Your ref:
Our ref: 22/00218/F
Please ask for: Miss Sandra Homcenko
Direct dial: 01553 616824
E-mail: borough.planning@west-norfolk.gov.uk

Details: **The proposals involve removing two rear painted brick extensions, reordering internal layout and external window/ door locations, extending the south elevation of the property and re-locating the front entrance. Conversion of attic space, including one new roof light and a dormer on rear elevation. Repair/ renew external render. at Stow Barn Stow Barn Road Crimplesham King's Lynn Norfolk**

Proposed Rear Elevation,
with dormer for bedroom

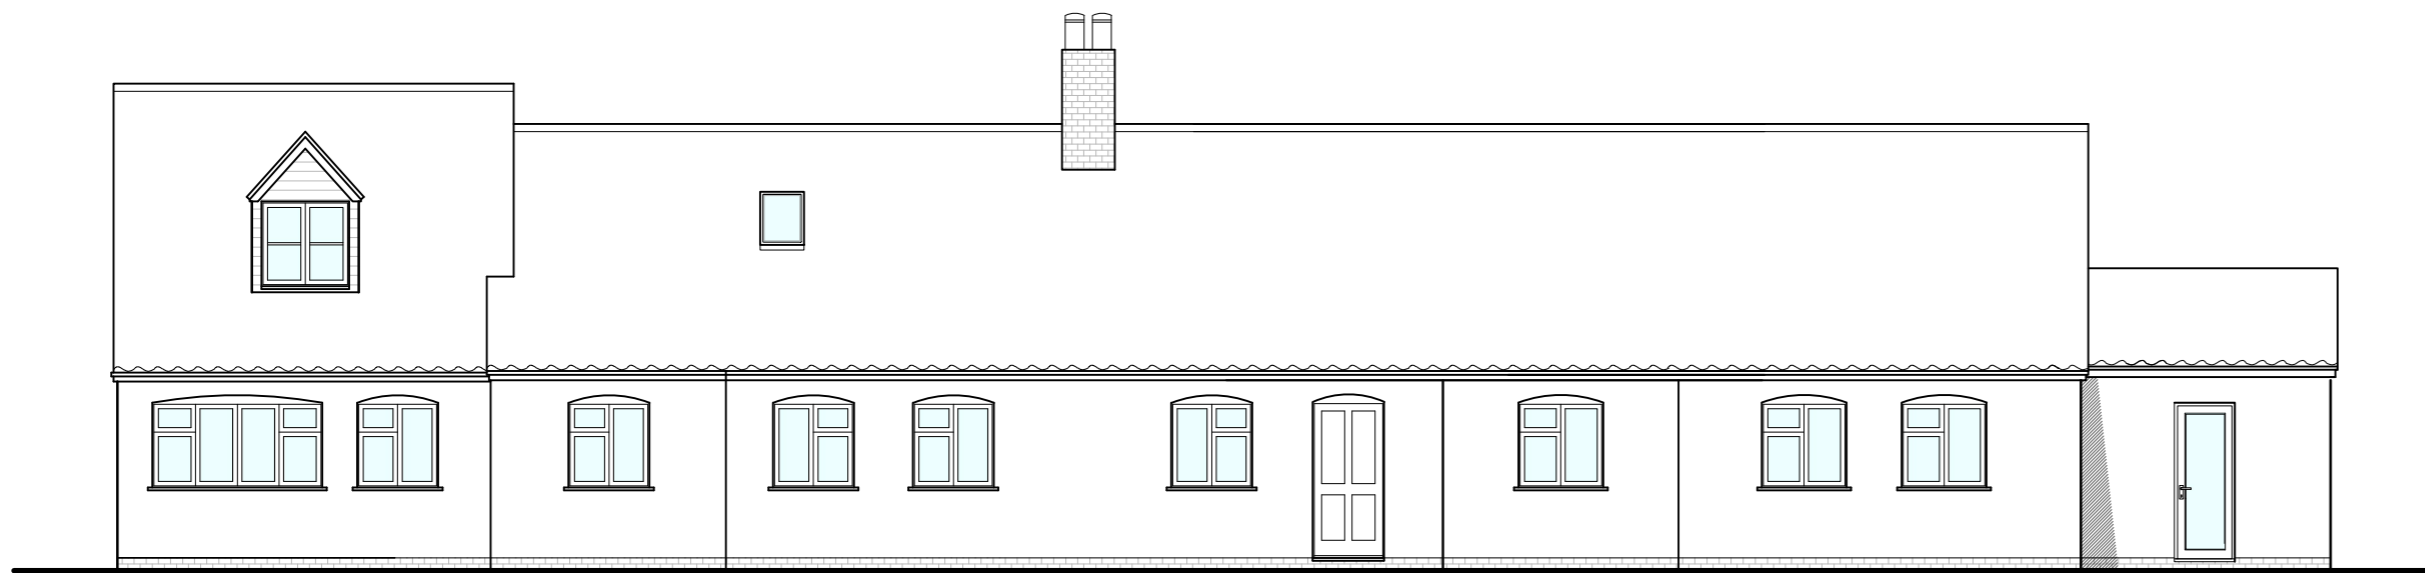
1. It appears that there is an error on the Proposed Rear Elevation please forward amended plans
